Our reference: EF13/3577: DOC14/24915-1
Contact: Stefan Press 02 6229 7002

11 March 2014

**RE: Shoalhaven Starches Pty Ltd - Proposal for minor modification to the DDG Pelletising Plant –
Section 75W EP&A Act - MP06_0228 –
Lot 62 DP 1078788, Bolong Rd, Bomaderry NSW.**

Plans of Proposed Modification to DDGS Pelletising Plant

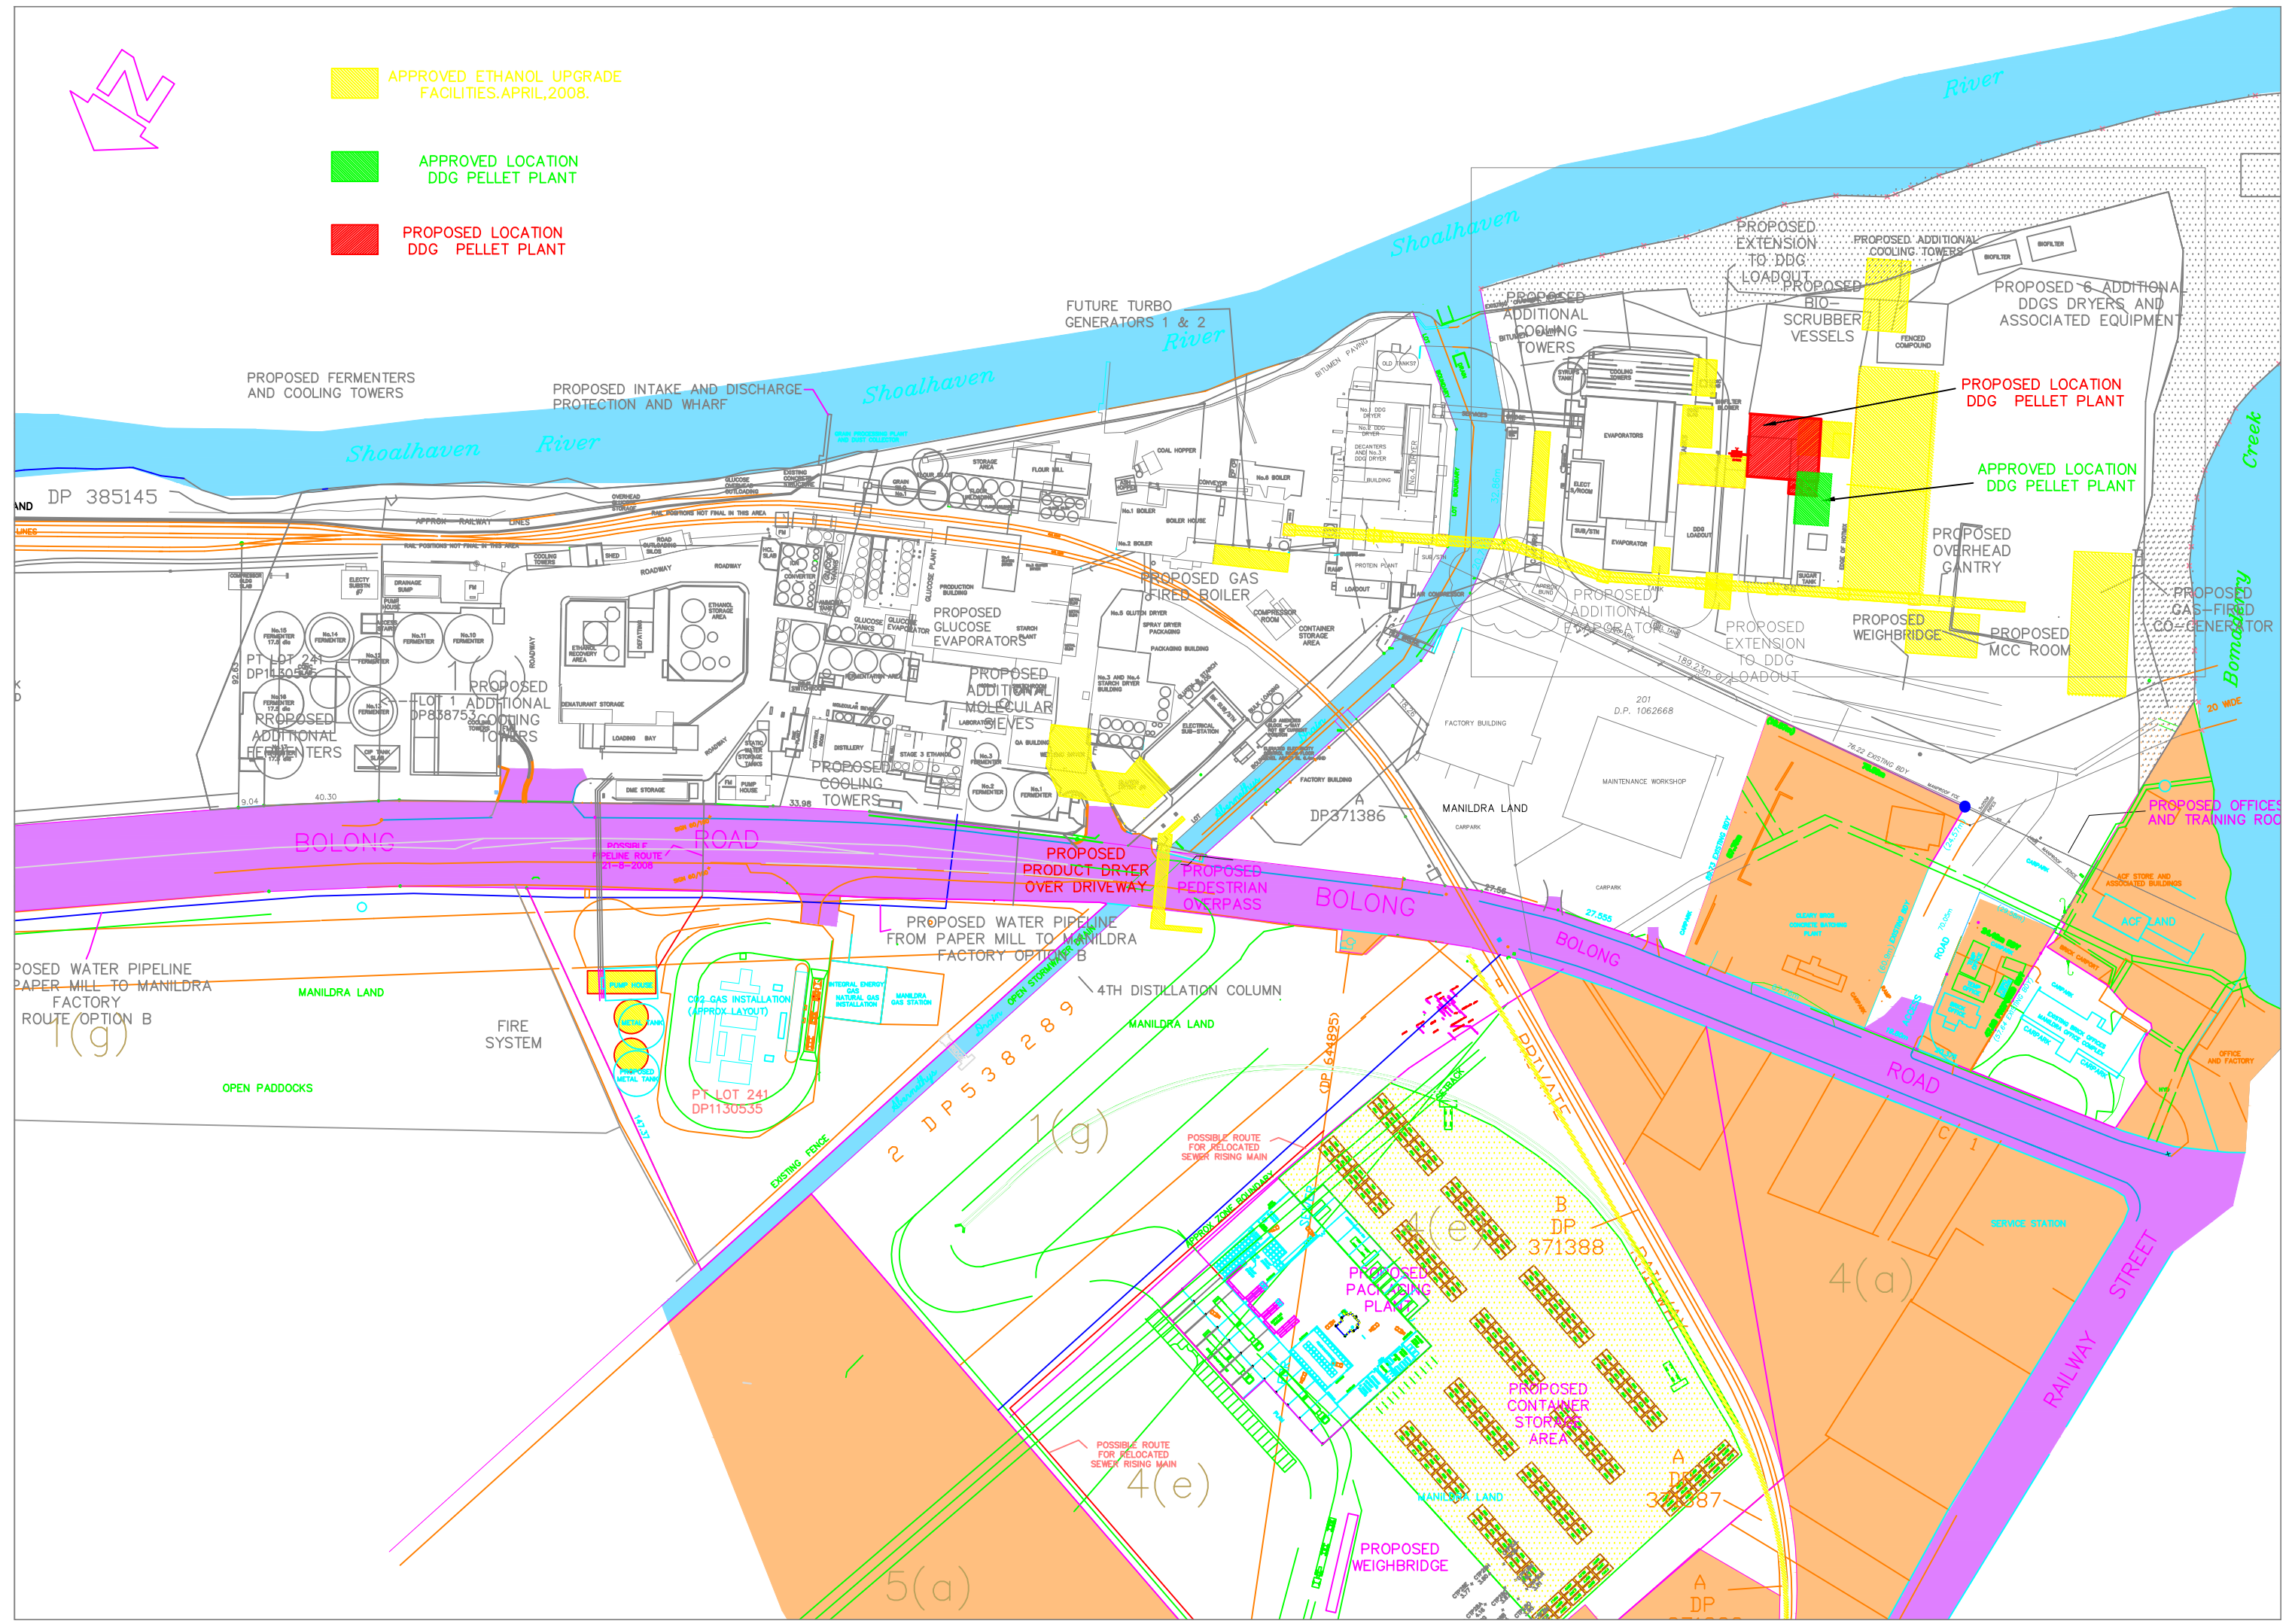
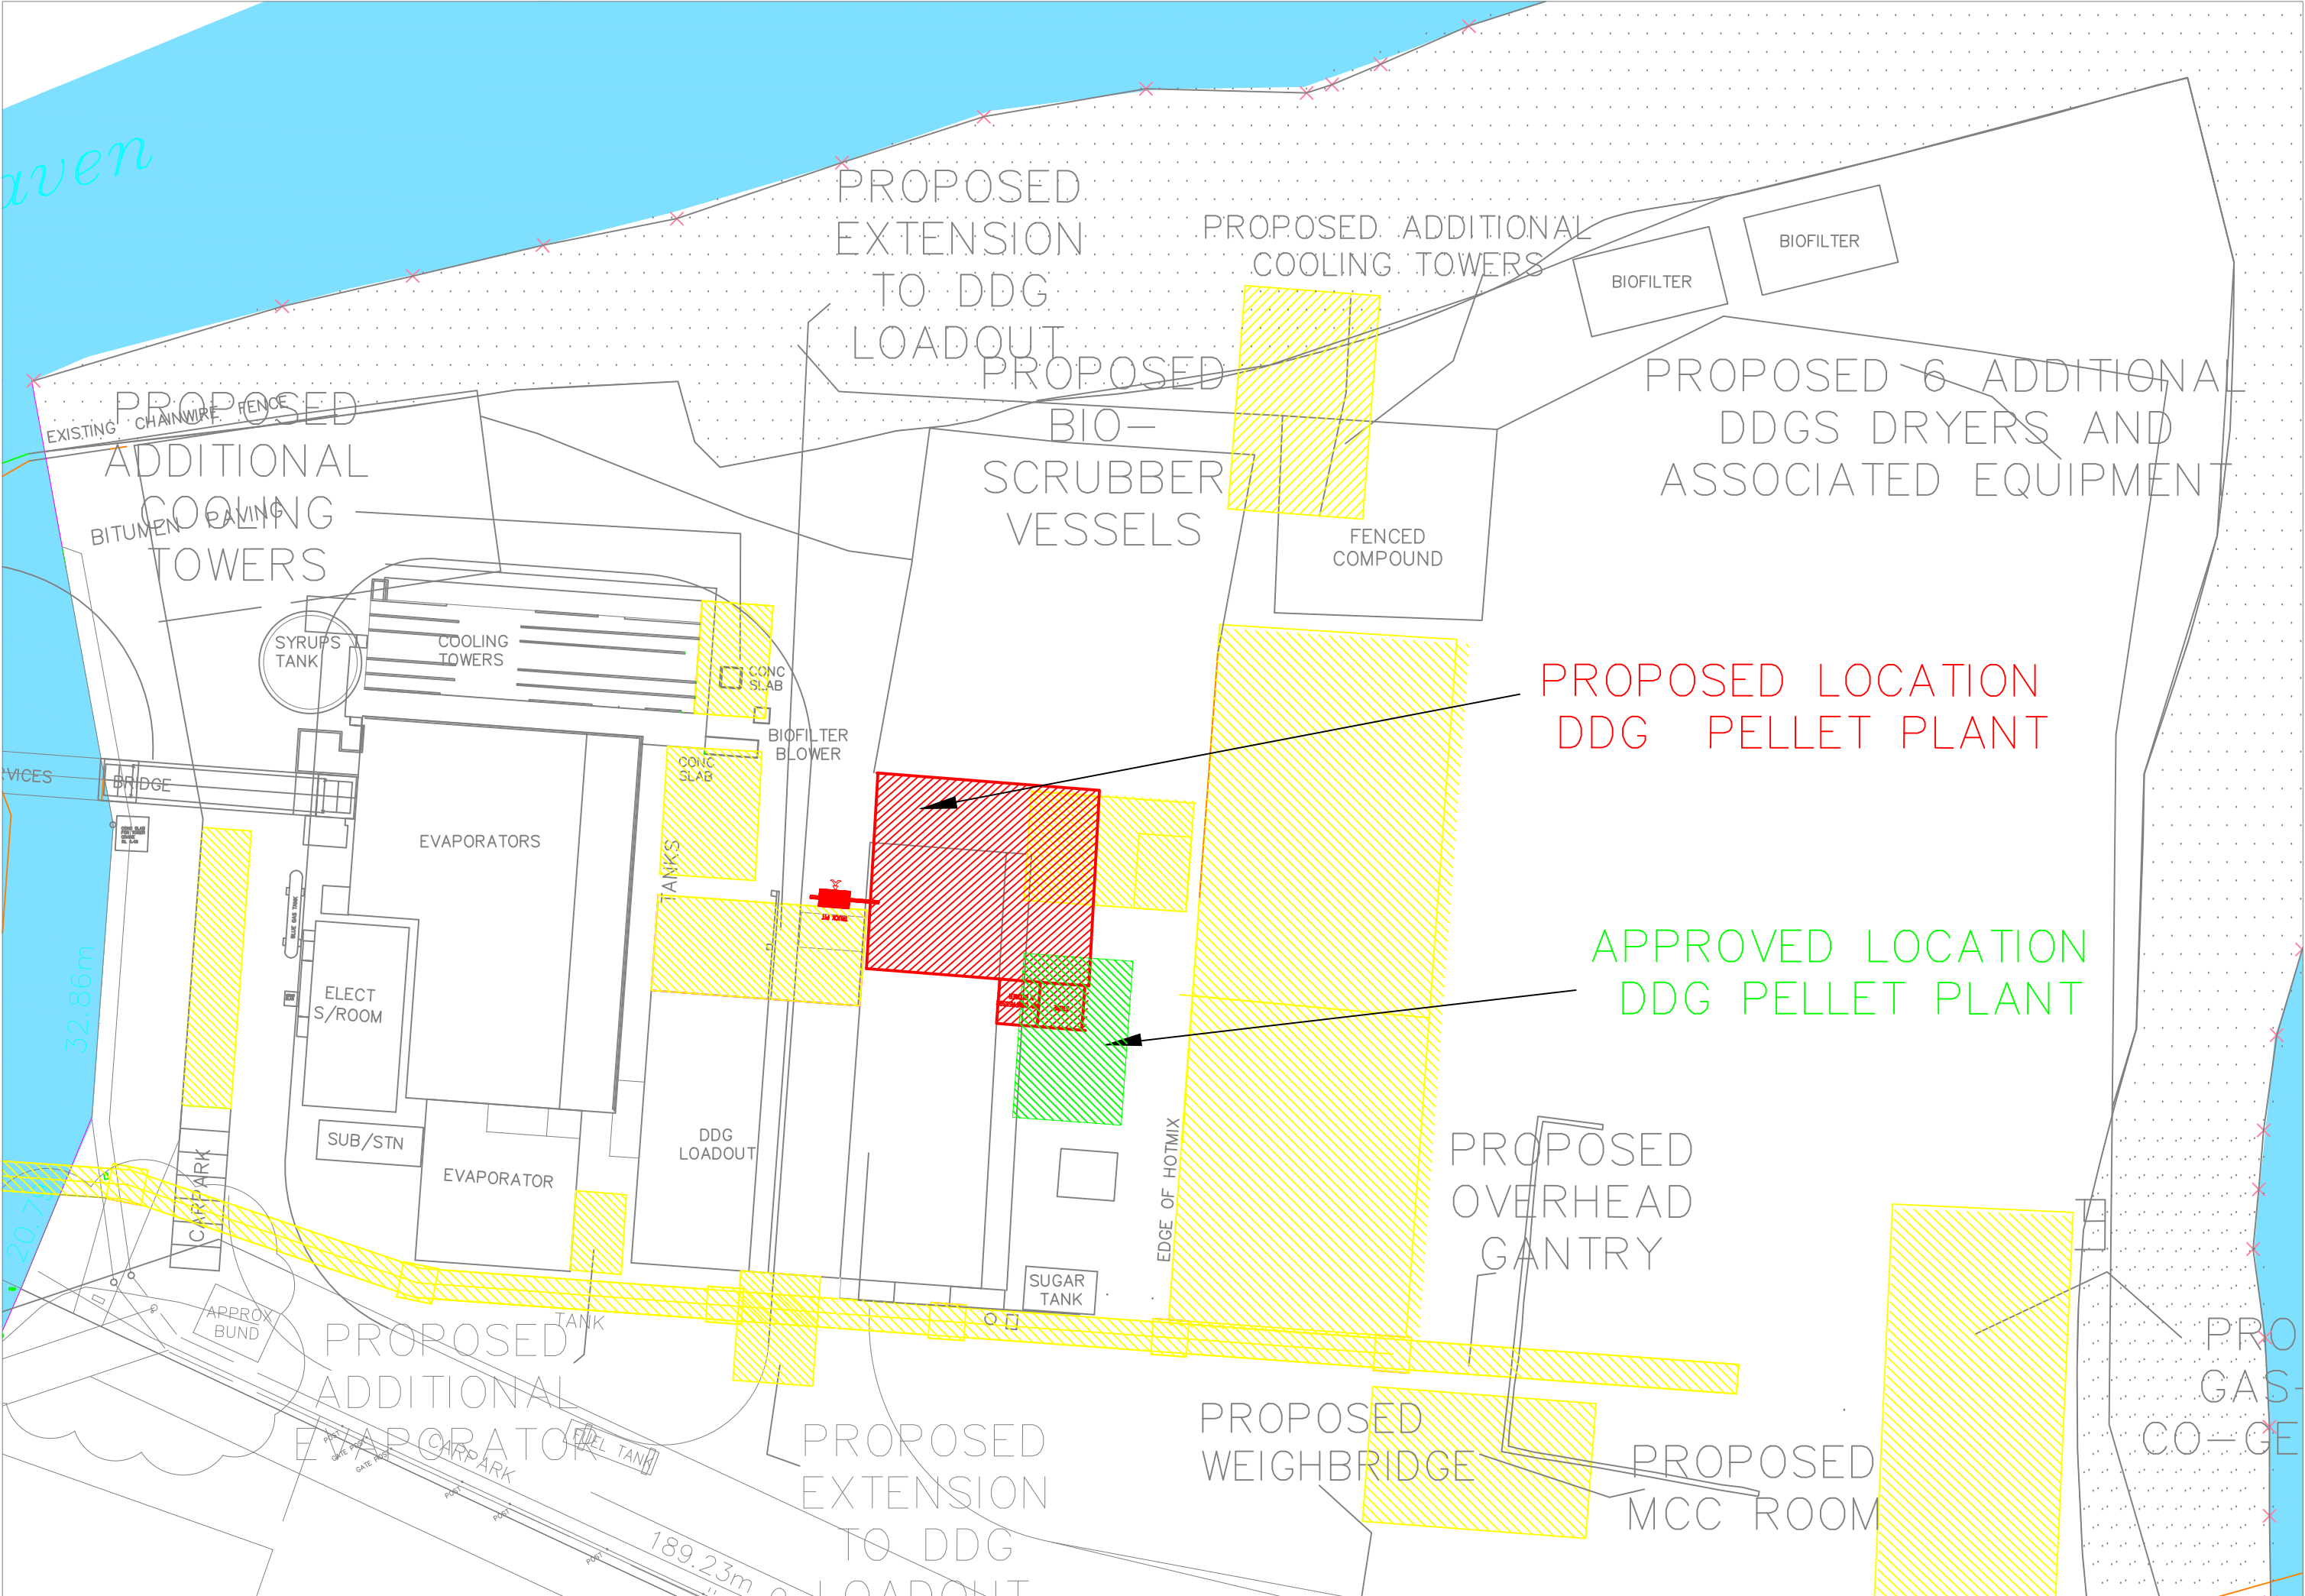
The EPA has reviewed the Environmental Assessment provided to support the proposed modification. The changes in location, size and height above ground level to the originally proposed development are consistent with the original environmental impacts identified in the Environmental Assessment for the development.

The EPA notes the Environmental Assessment states that the air emissions from the proposed DDG pelletising plant are to be conveyed to the existing biofilters for odour treatment. The EPA recommends that prior to any approval for this modification that Shoalhaven Starches demonstrates there is sufficient capacity in the biofilters to effectively treat the additional odorous air streams from the DDG pelletising plant, or whether additional odour treatment capacity will be required.
